Re: Objection to MP08_0244 MOD 1 Modification Request for Mixed Used Development at 23-37 Lindfield Avenue and 11 Havilah Lane, Lindfield

3 SHADOW DIAGRAM - 21stDEC_3PM
5003 SCALE1 : 650

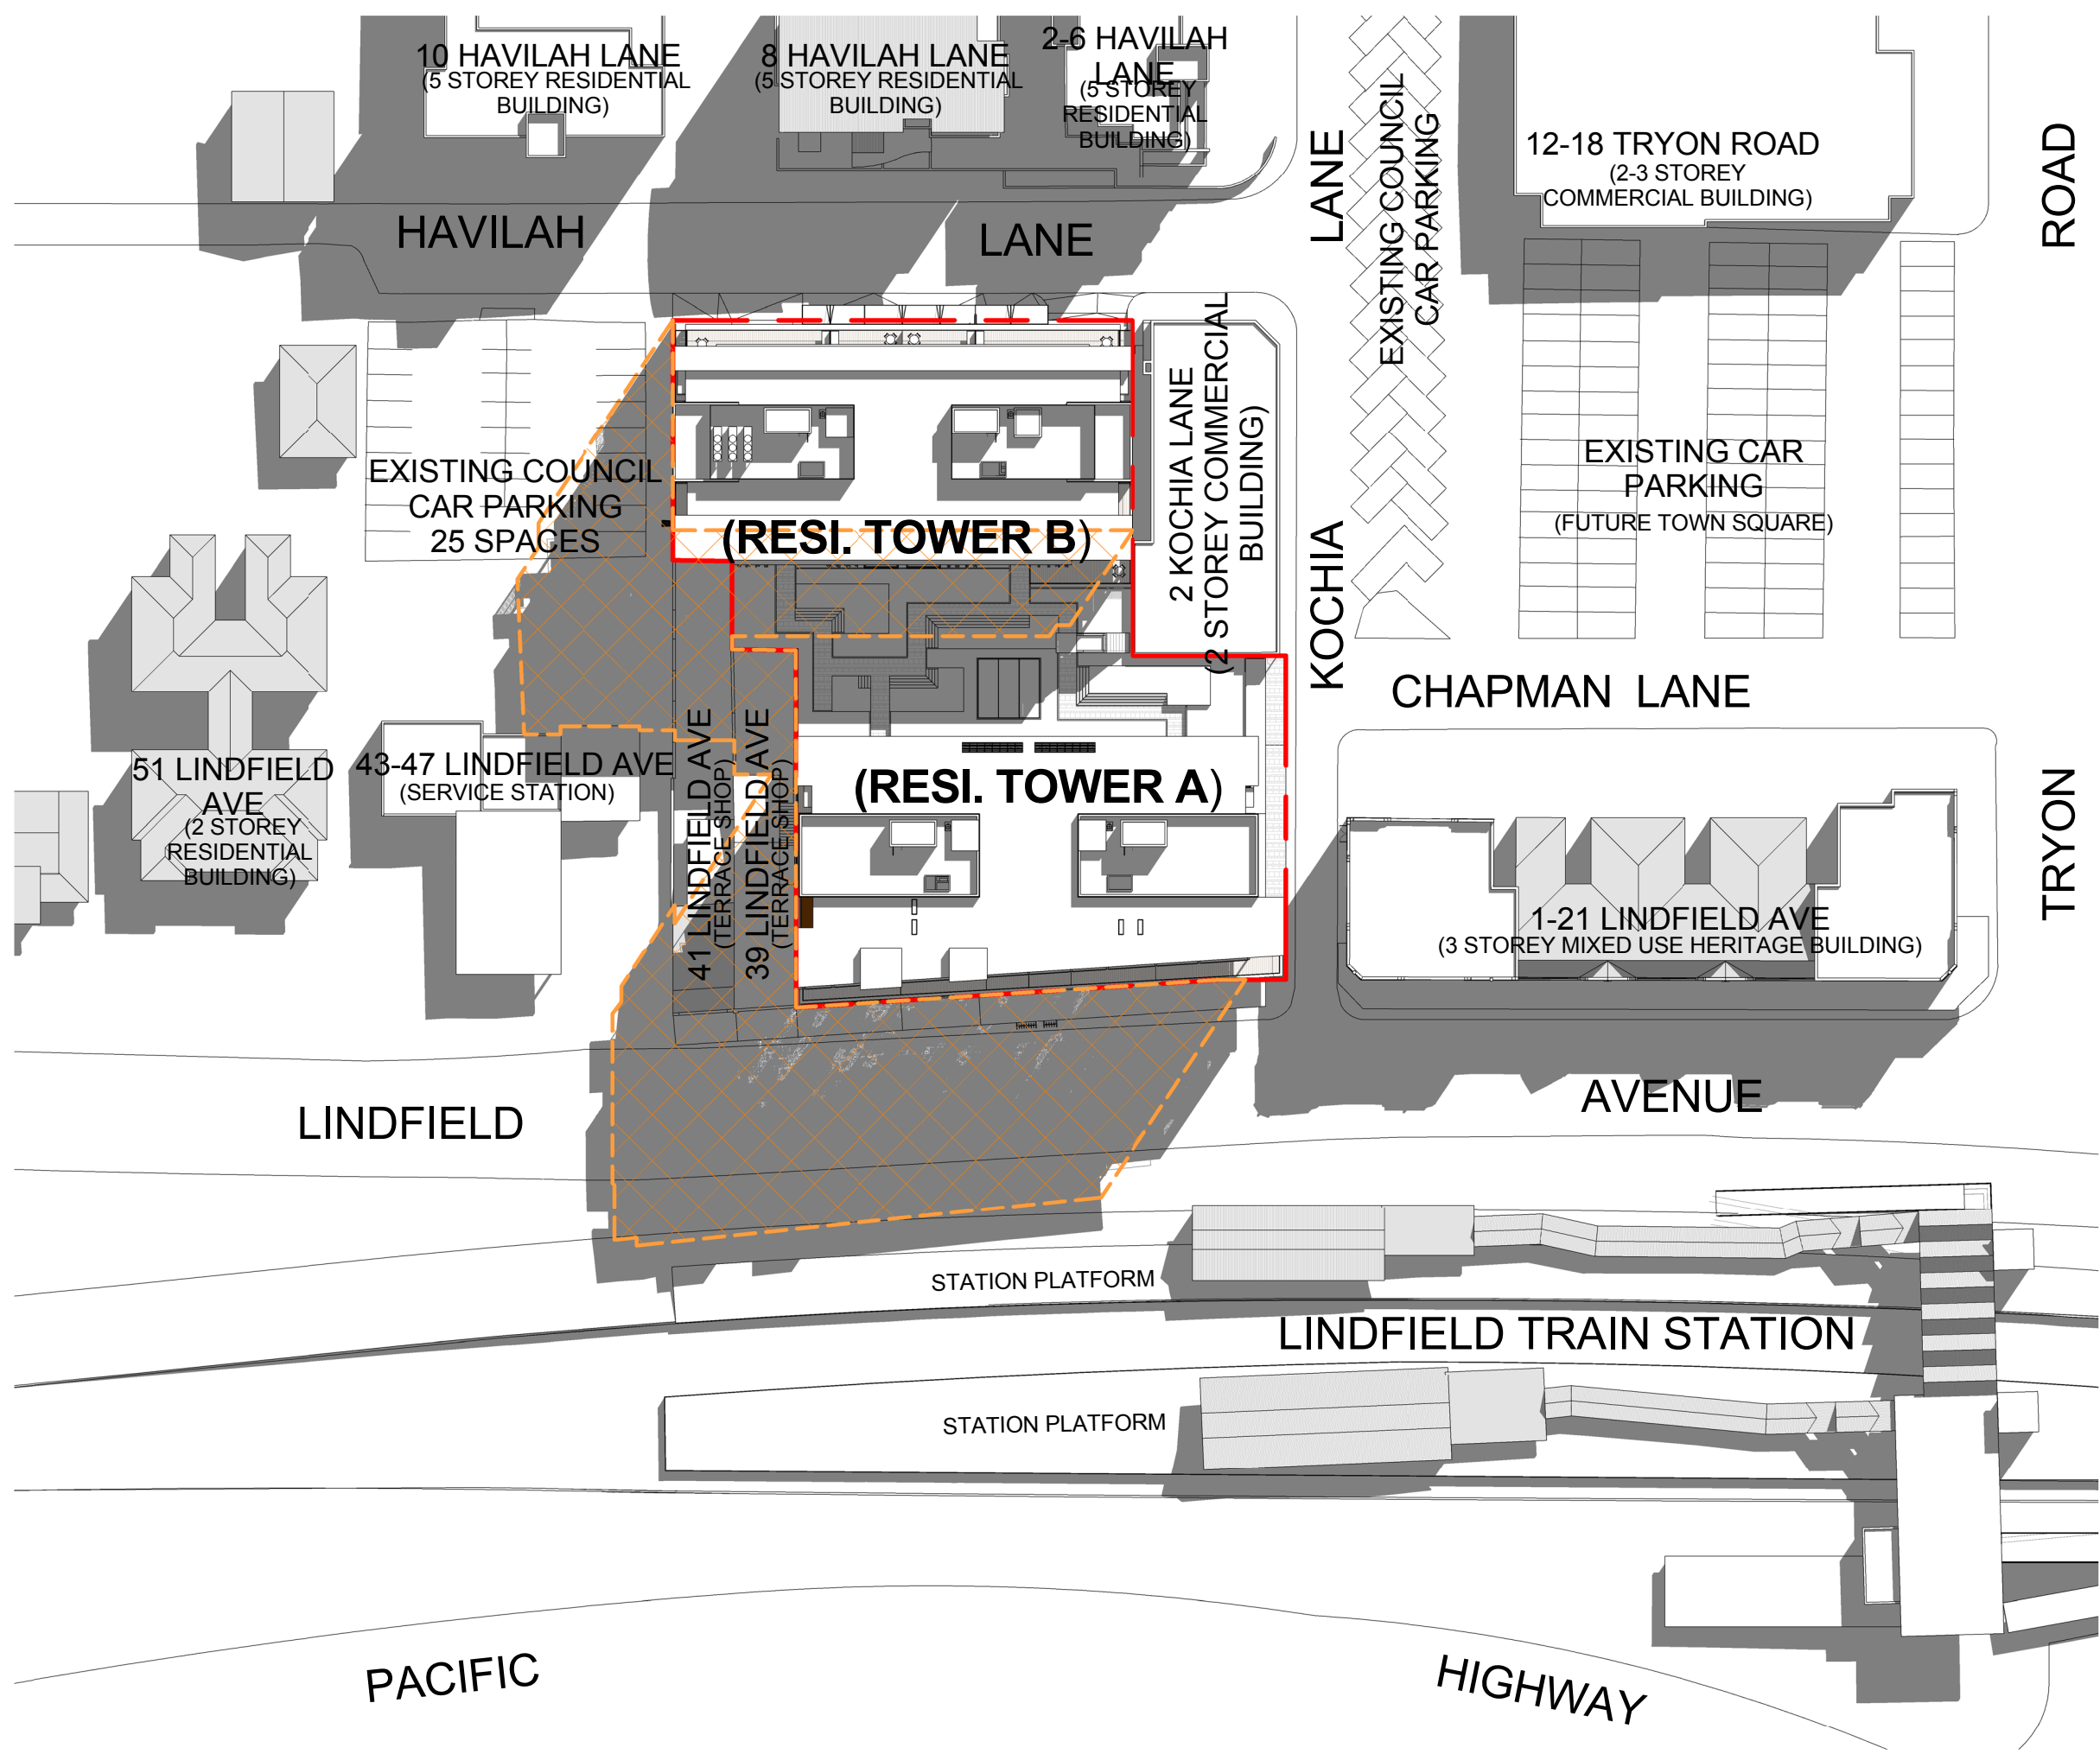
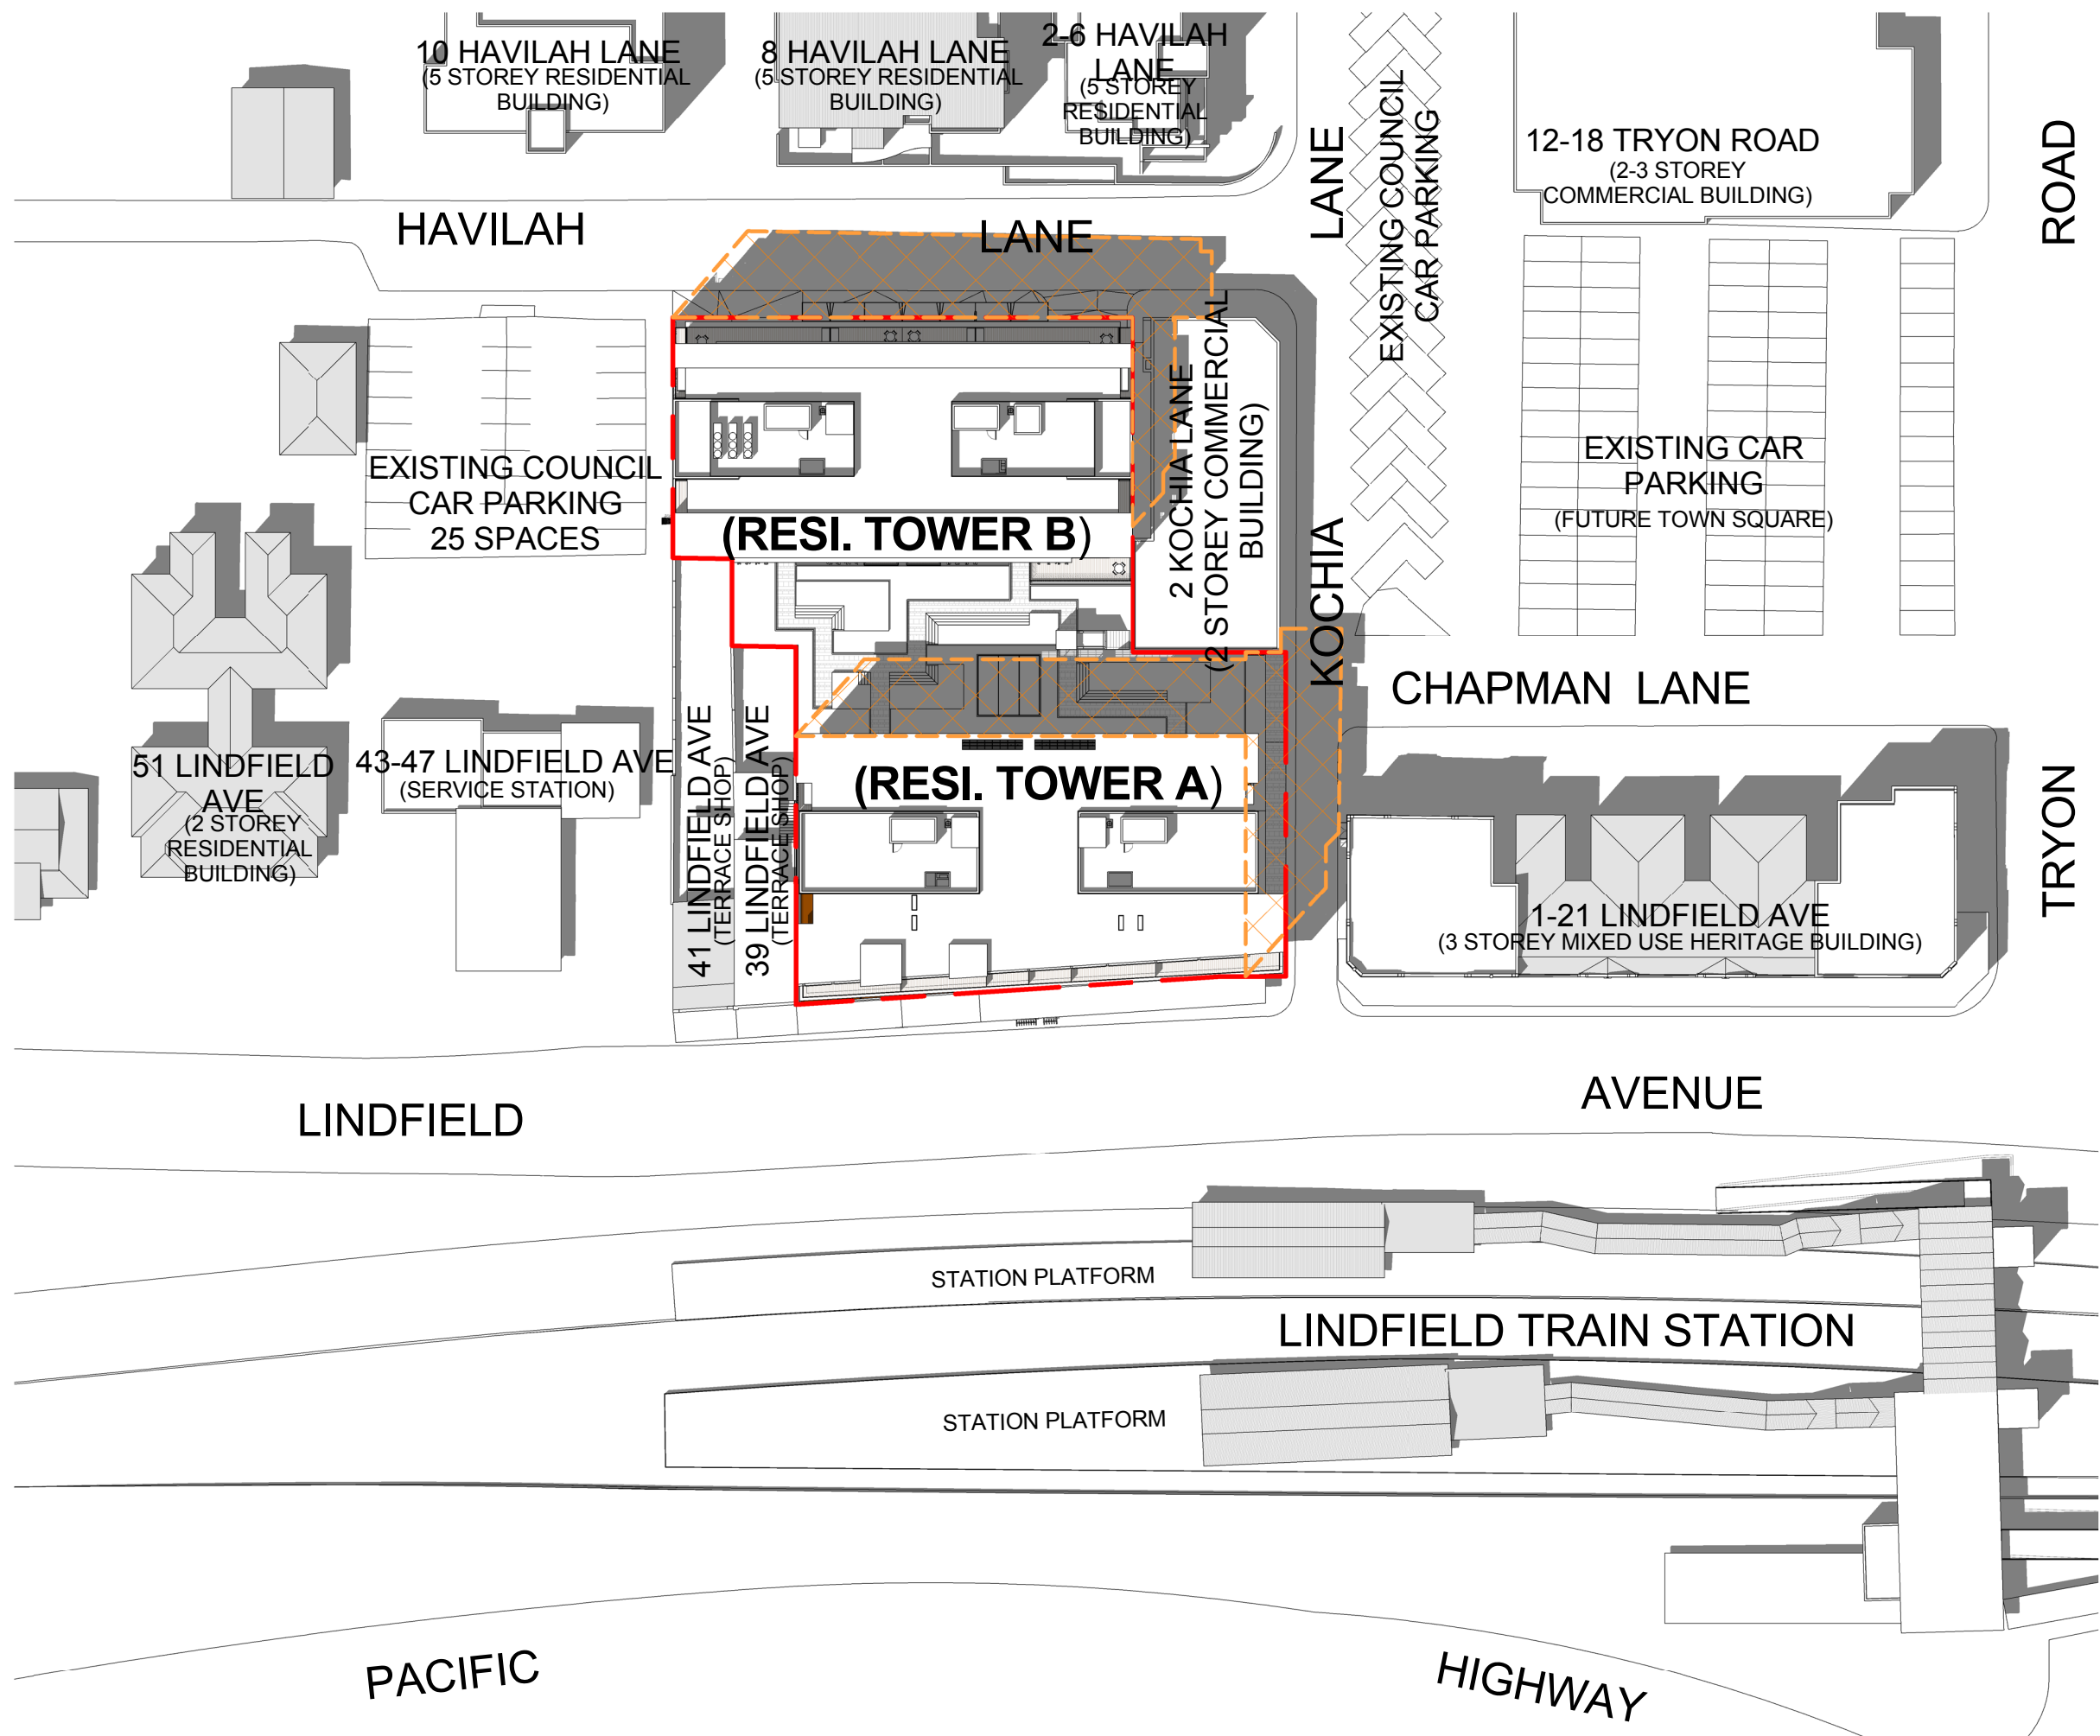
- The additional storeys create new adverse shadowing: a) for residents in the Havilah Lane apartments, particularly after 3pm b) for the popular outdoor café and central Lindfield hub area at 12 Tryon Road in afternoons, particularly in winter and c) for all commuters on the city bound Lindfield rail platform, instead of 50% of the year as approved, it will now be in shadow in the mornings 75% of the year
